WPWR-MWA-XX-XX-RP-A-0003

Planning Amendments

Vehicle Maintenance Workshop

Whaley Road

North-East
1 : 100

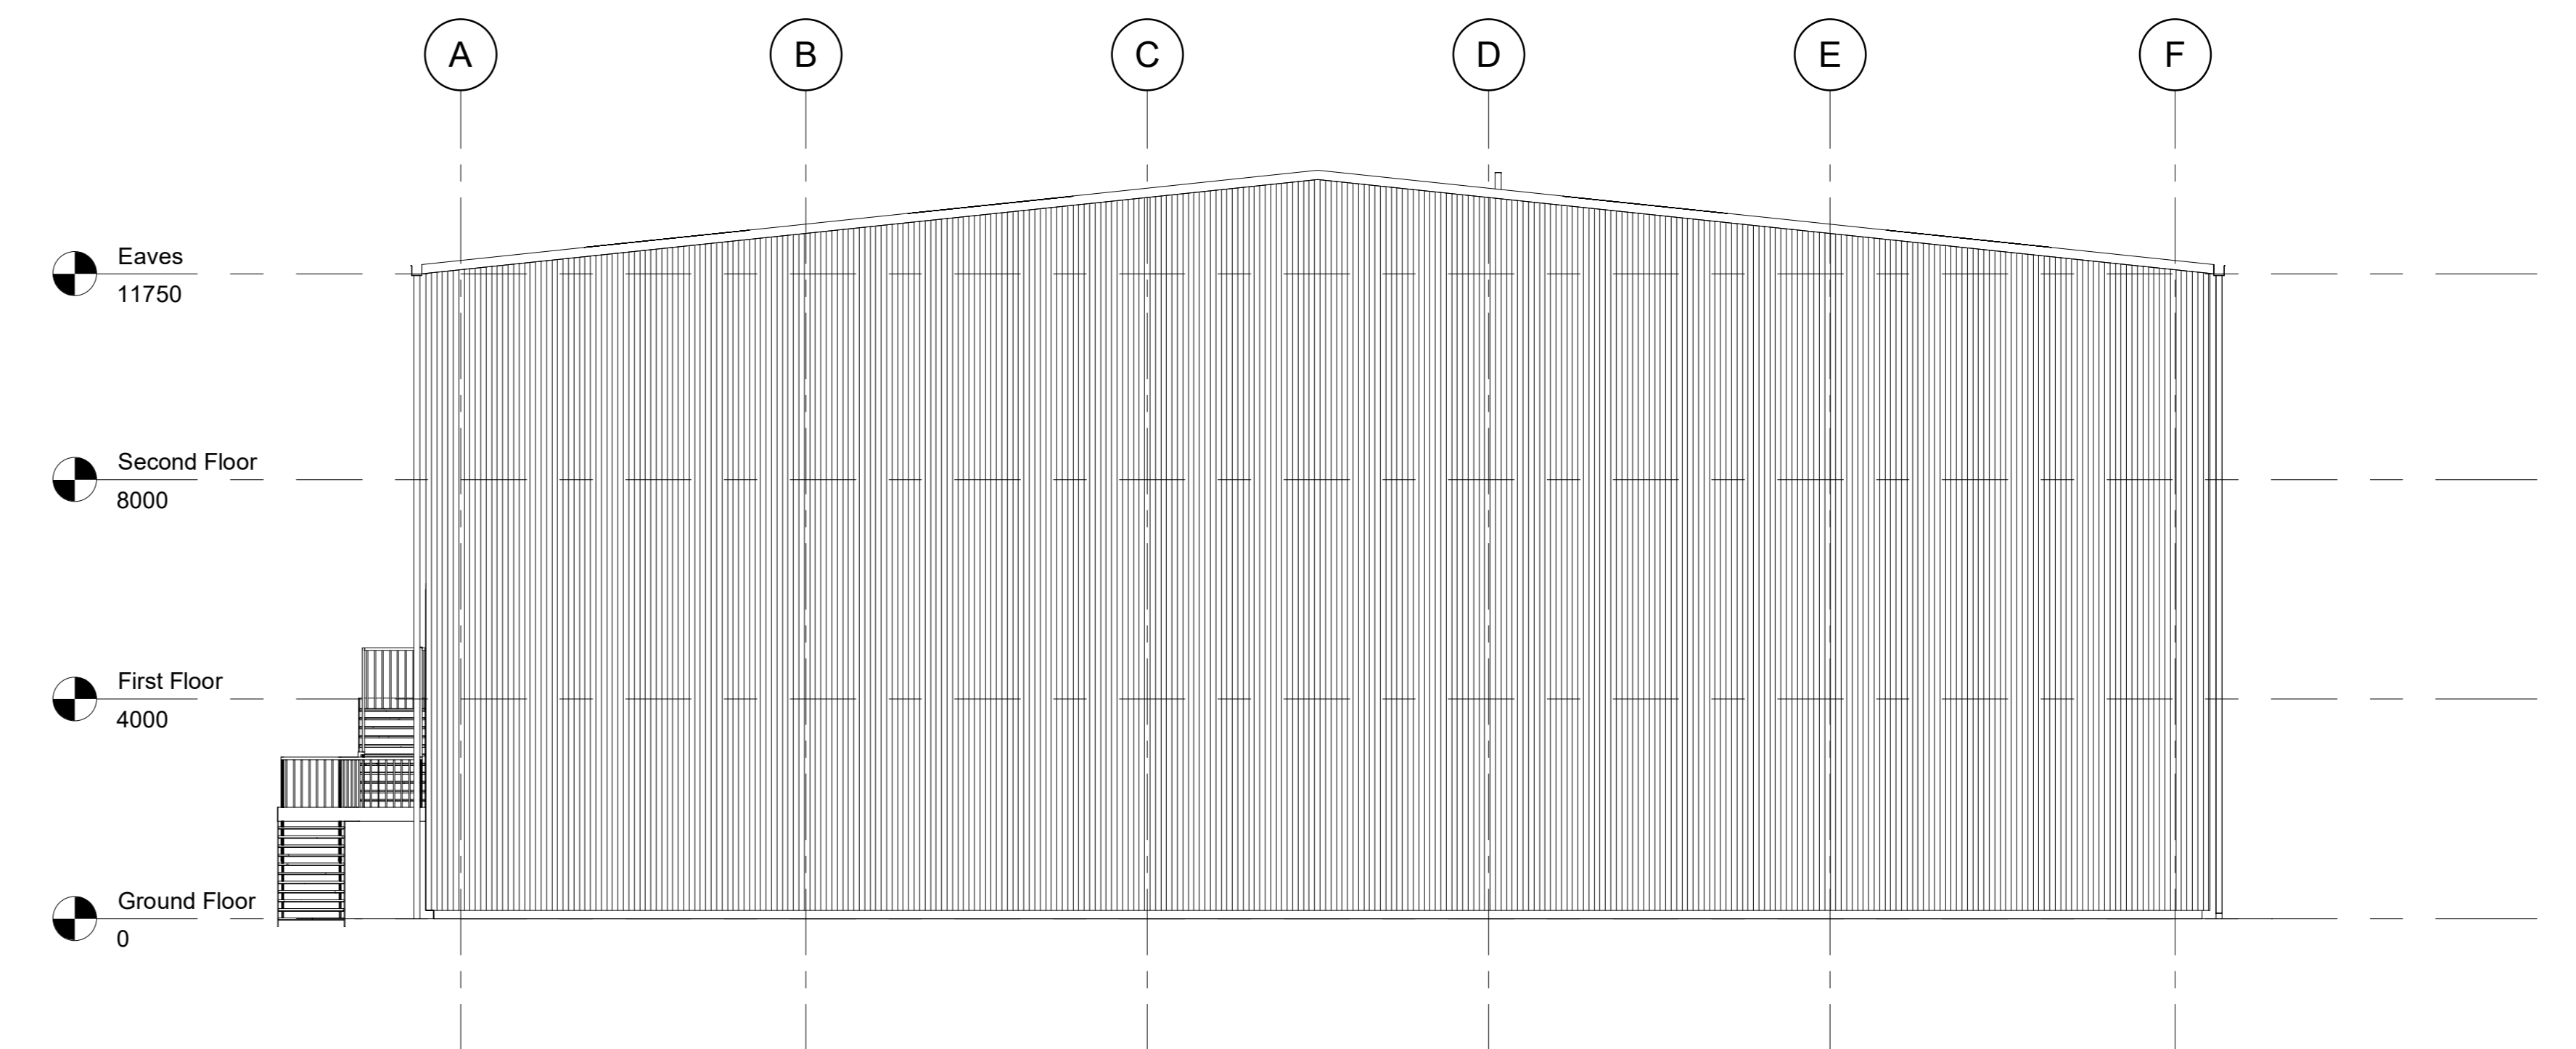
Four of the eight roller shutter doors reduced in width by 1m.

Note re solar panels added to drawings – PV will be required to meet Building Regulations energy standards

There is no change to the elevation facing the closest neighbouring site to the north-west
